Our Ref: LU/336/17/HH
Your Ref:

Town & Country Planning Act 1990 (as amended)
Town & country Planning (Development Management Procedure) (England) Order 2015
Application for Planning Permission for Works or Extension to a Dwelling

Development Creation of first floor side extension above garage, creation of dormer in existing roof room, erection of porch & creation of utility within existing garage
Location 17 Holly Drive Littlehampton

View: PROPOSED 2ND FLOOR PLAN

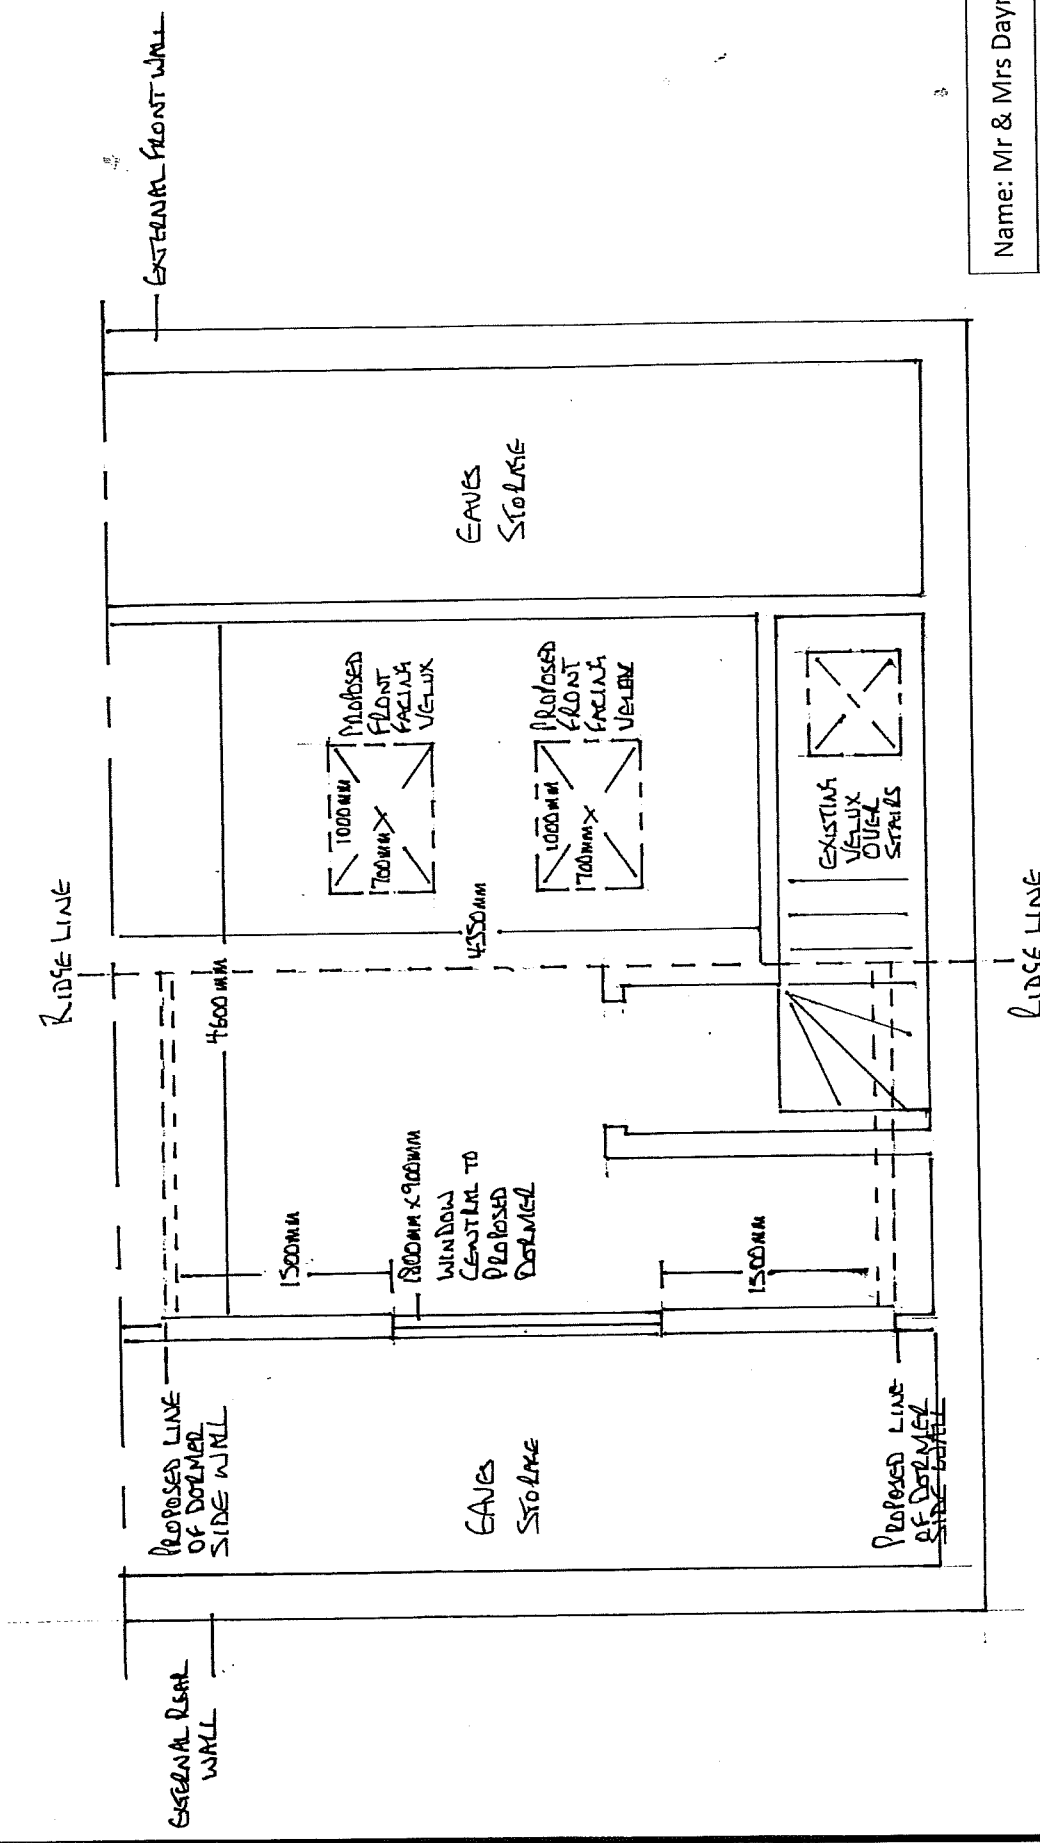
Please indicate clearly on the proposed 2nd floor plan where exactly the windows in the dormer are to be positioned

Name: Mr & Mrs Dayman
Address: 17 Holly Drive, Littlehampton, West Sussex, BN17 6LB.
View: RIGHT HAND SIDE OF VIEWS FROM THE ROAD ELEVATION
Scale: 1:50

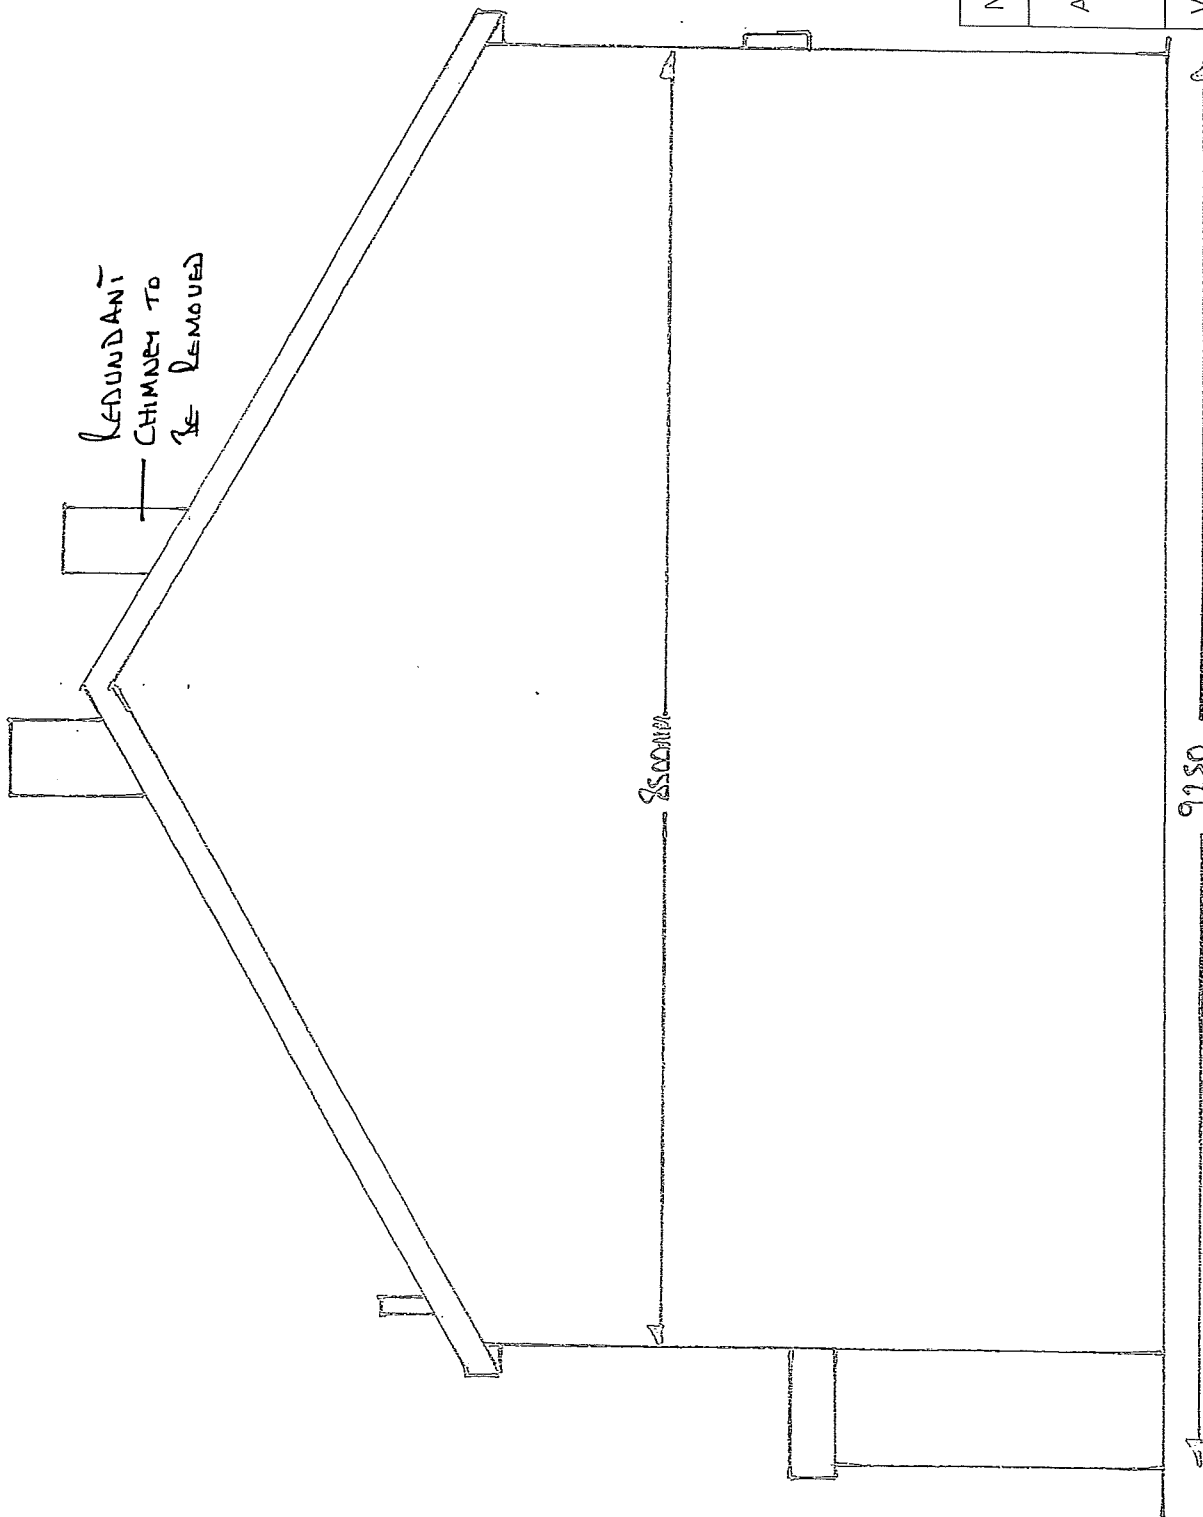
Please could you amend the annotation on the submitted left hand and right hand side elevation to read either Existing or Proposed.
